Subject: RE: LU/426/17/DOC - Approval of acoustic barrier for Fitzalan Relief Road - WSCC highways response dated 25th January 2018

I have viewed the revised drawings A088461 FL1 & 2 Rev J 8 February 2018 re the proposed acoustic fence.

Fitzalan Link
S278 Works: Landscape
Proposals 1 of 2

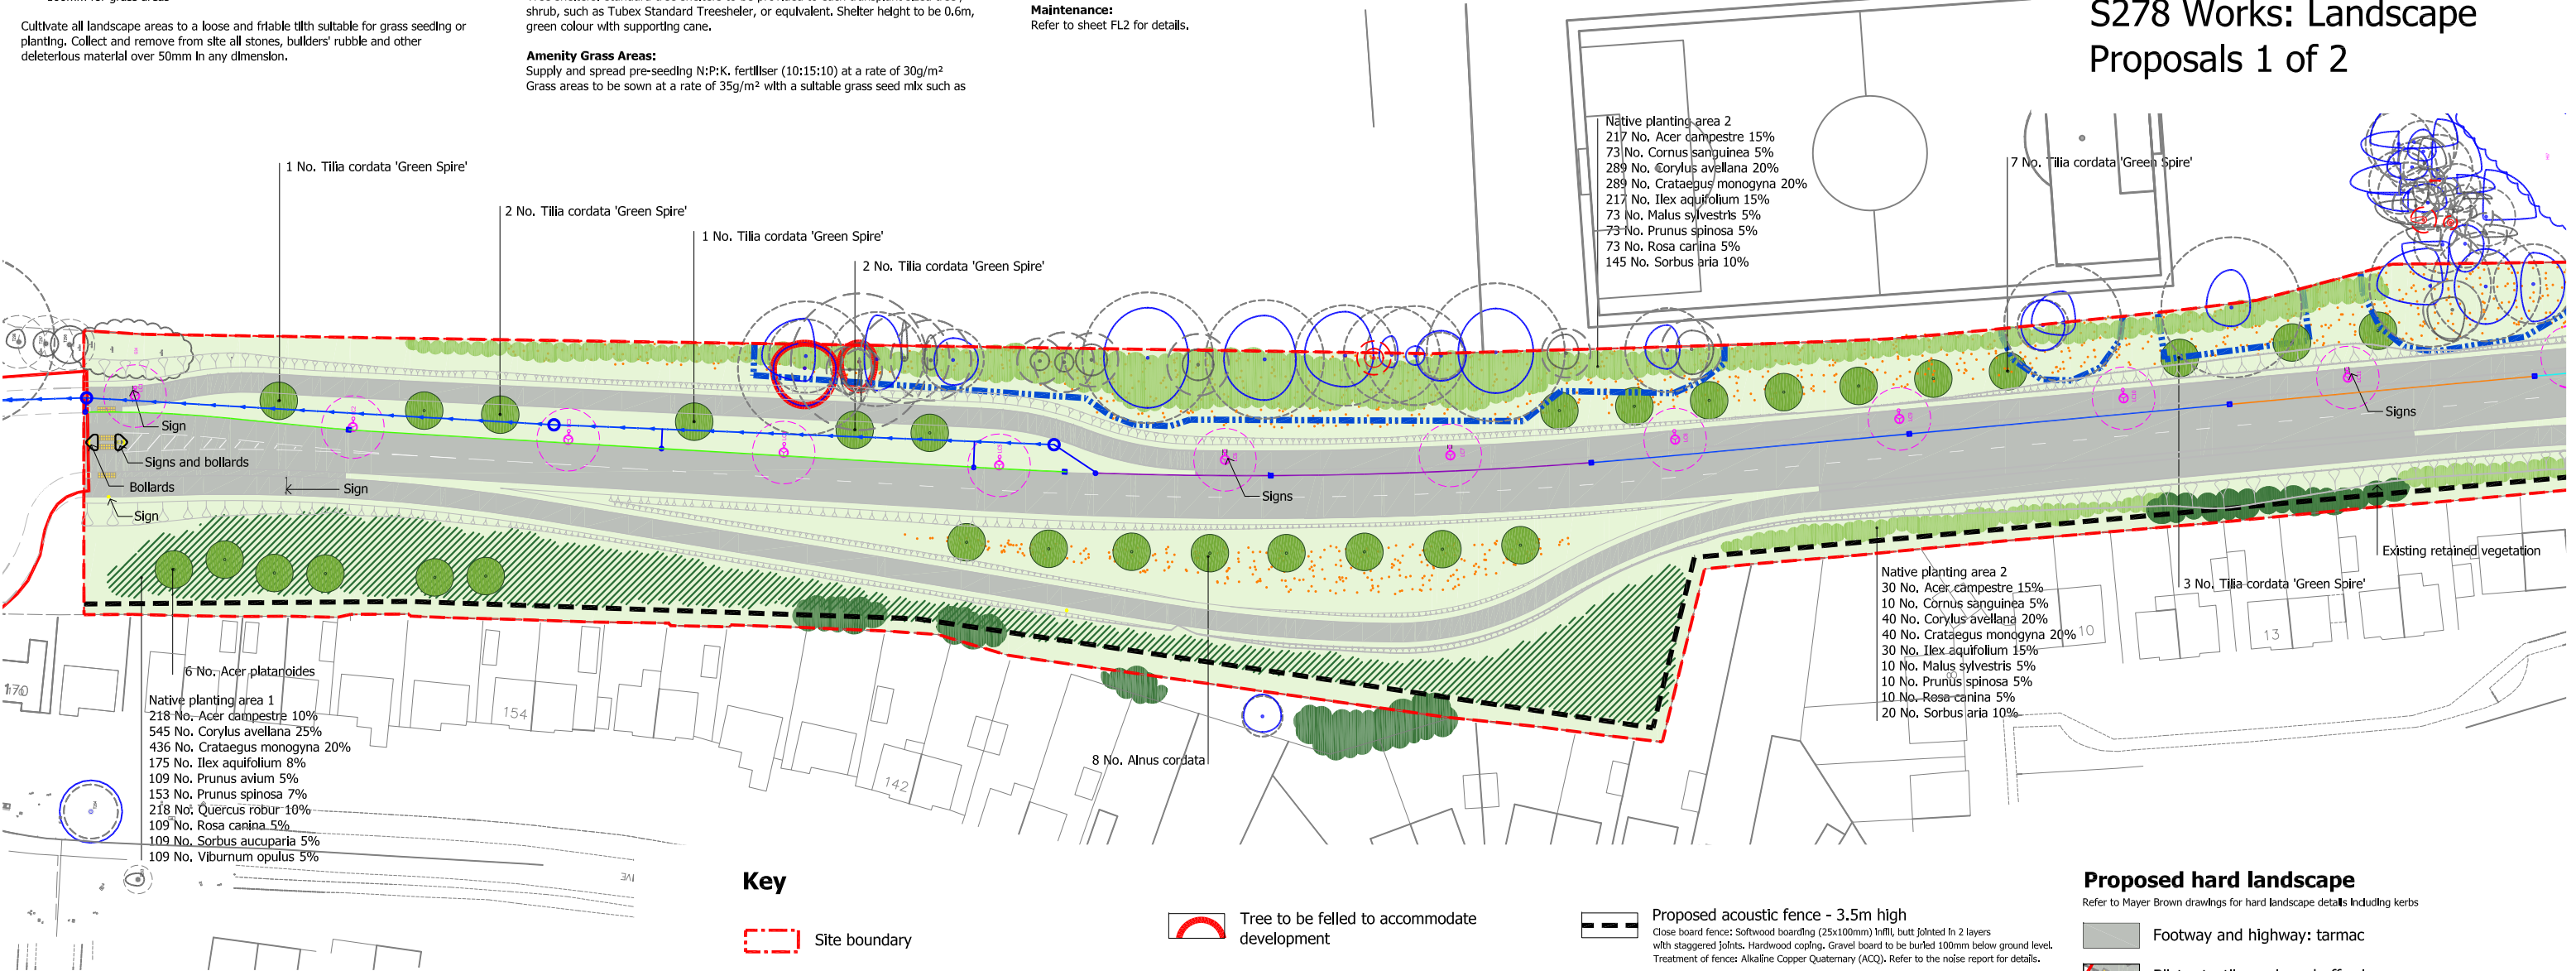
Having looked at the proposals, the planned landscaping, the topography of the land, location and orientation I have concluded that it would be impractical to propose planting to the area to the west (house side) of the proposed acoustic fence.

A combination of lack of space, the proximity in relation to the rear garden boundaries, the practicality in maintaining this space, the issue with this being 'made up' ground and the westerly aspect of these areas would all lead to the impracticality of installing, the difficulty in establishing and maintaining and the potential for future issue to homeowners to the west if additional landscaping were installed in this area.

We would therefore recommend no objection on landscape grounds to the landscape proposals submitted under application LU/427/17/DOC and would be happy to recommend discharge of any landscape condition under this application. We wouldn't be recommending the addition of any additional landscaping other than that shown in the drawings detailed above.
